A38 Derby Junctions
TR010022

8.71 Written Summary of Oral
Submissions to ISH4 19 February 2020

**Written Summary of Oral Submissions to ISH4
19 February 2020**

Viewpoint 24

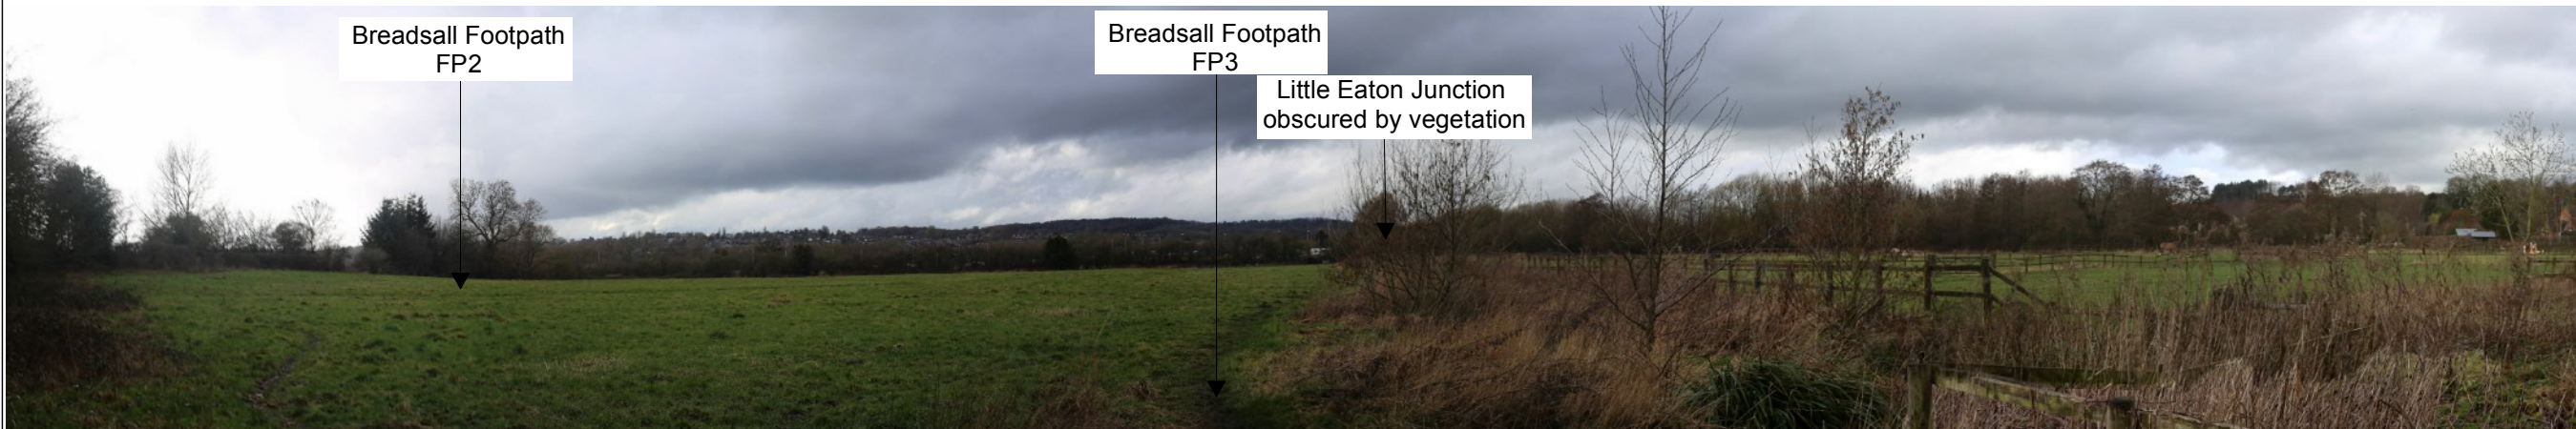
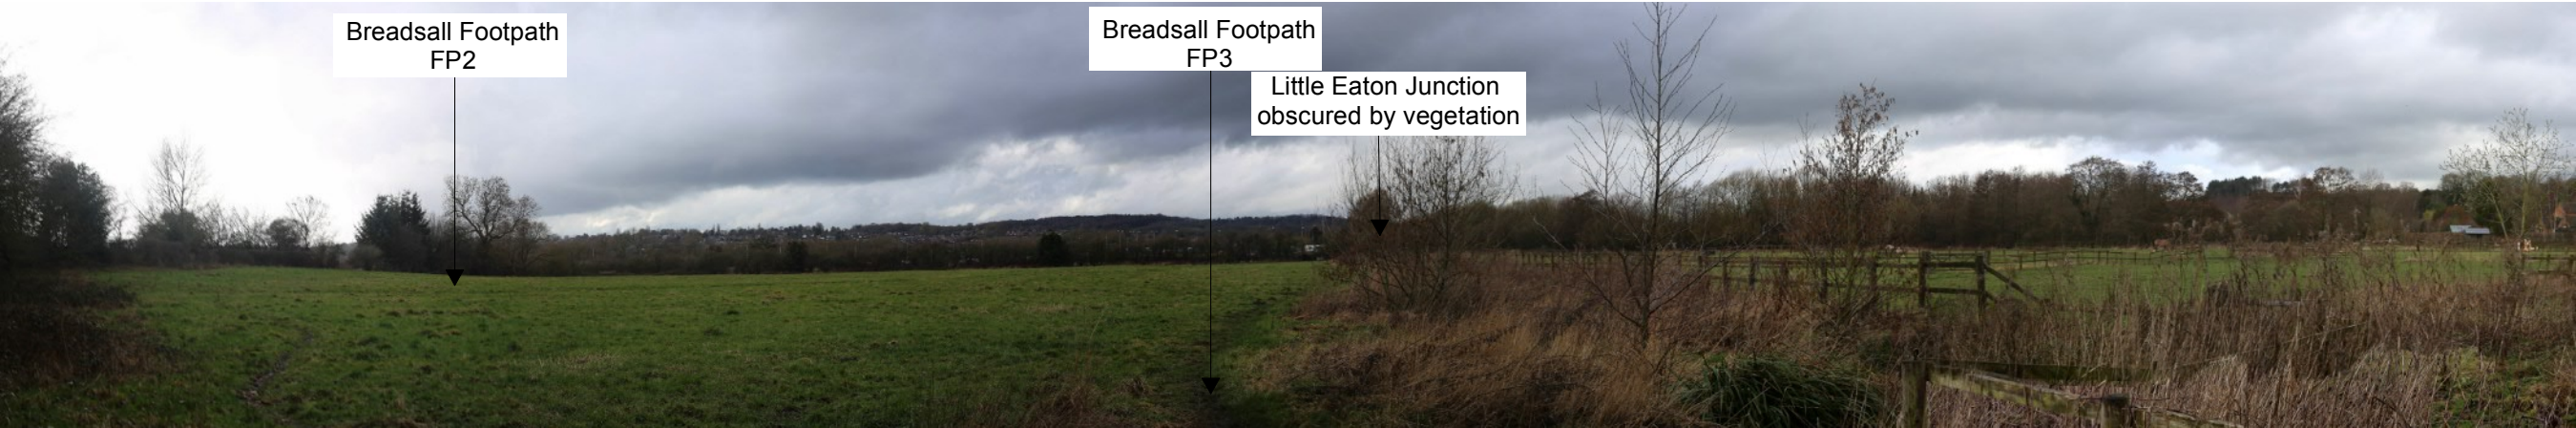
<p>Item 7</p>	<p>Landscape and visual impact</p> <p>a) Landscape screen planting at Little Eaton junction.</p>	<p>HE referred to photomontage 24 which shows proposed planting in position at year 15. HE explained that the narrow belt of trees are those in front of the environmental barrier. On the embankment up to the flyover, there will be trees that will screen the A38 with a</p>

ExA's Question/ Issue no.	ExA's Question/ Issue	Summary of Oral Responses by Highways England
		<p>10-metre belt behind it. HE confirmed that the montage view was taken from point 24 on the screen from a public footpath.</p> <p>In response to the ExA noting that the photomontage is at a lower level and that the views from the village would be slightly different HE explained that beyond the footpath there is a further treeline.</p> <p>HE confirmed that there will be planting in that area. There will be a discussion as to what the planting is at detailed design stage. Species mix will be of importance and this will be driven by the local authority's guidance. Consultation with Breadsall Parish Council would be conducted via the councils not HE.</p> <p>DCC gave an undertaking that it would liaise with Breadsall PCs. DCC confirmed that it was satisfied with what has been put forward.</p>
